Your ref:  
Our ref: 21/00347/F  
Please ask for: Miss Sandra Homcenko  
Direct dial: 01553 616824  
Direct fax: 01553 616652  
E-mail: borough.planning@west-norfolk.gov.uk

Details: **In fill front elevation recess and project with a single storey flat roof porch and cloak room at Fairholme 54 Common Lane North Runcton King's Lynn Norfolk**

I have received a planning application as detailed above but cannot process it until I receive some more information:

Title: **PROPOSED GROUND
FLOOR PLAN +
ELEVATION**

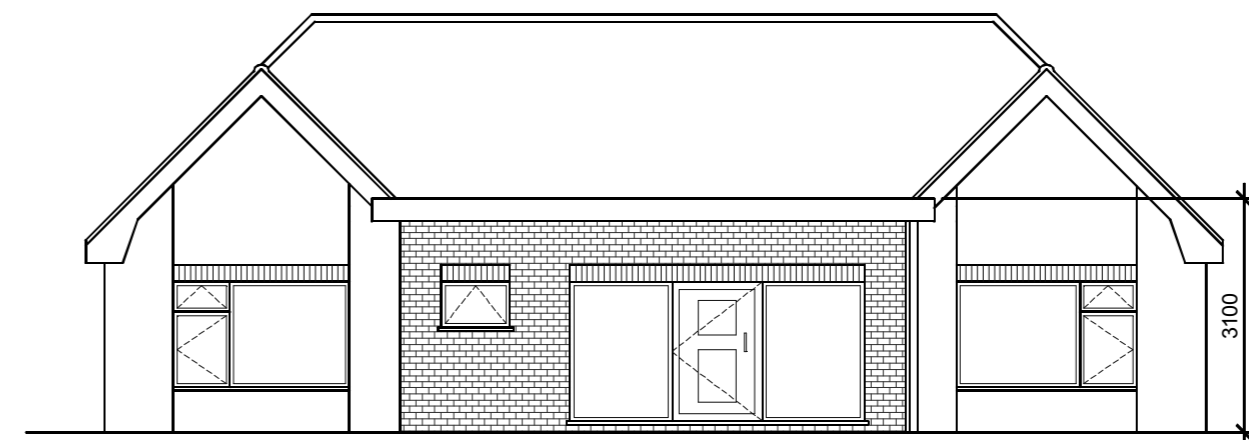
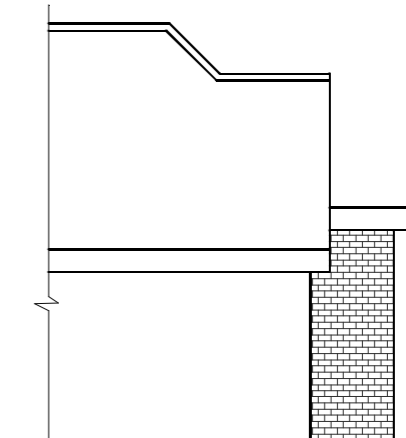
1. Please provide Proposed and Existing side elevations
2. In accordance with the National Validation Checklist, which became mandatory on 6 May 2008, we will require information regarding site levels. If site levels are to change, please provide four copies of a site survey drawing, alternatively, if site levels are to remain unchanged, this can be annotated on the relevant plan or advised in writing.
3. As the property lies within an area at risk to flooding, please complete the simplified Matrix and return it. The Matrix can be found at [https://www.west-norfolk.gov.uk/info/20173/information\\_for\\_planning\\_agents/231/flood\\_risk\\_information](https://www.west-norfolk.gov.uk/info/20173/information_for_planning_agents/231/flood_risk_information)
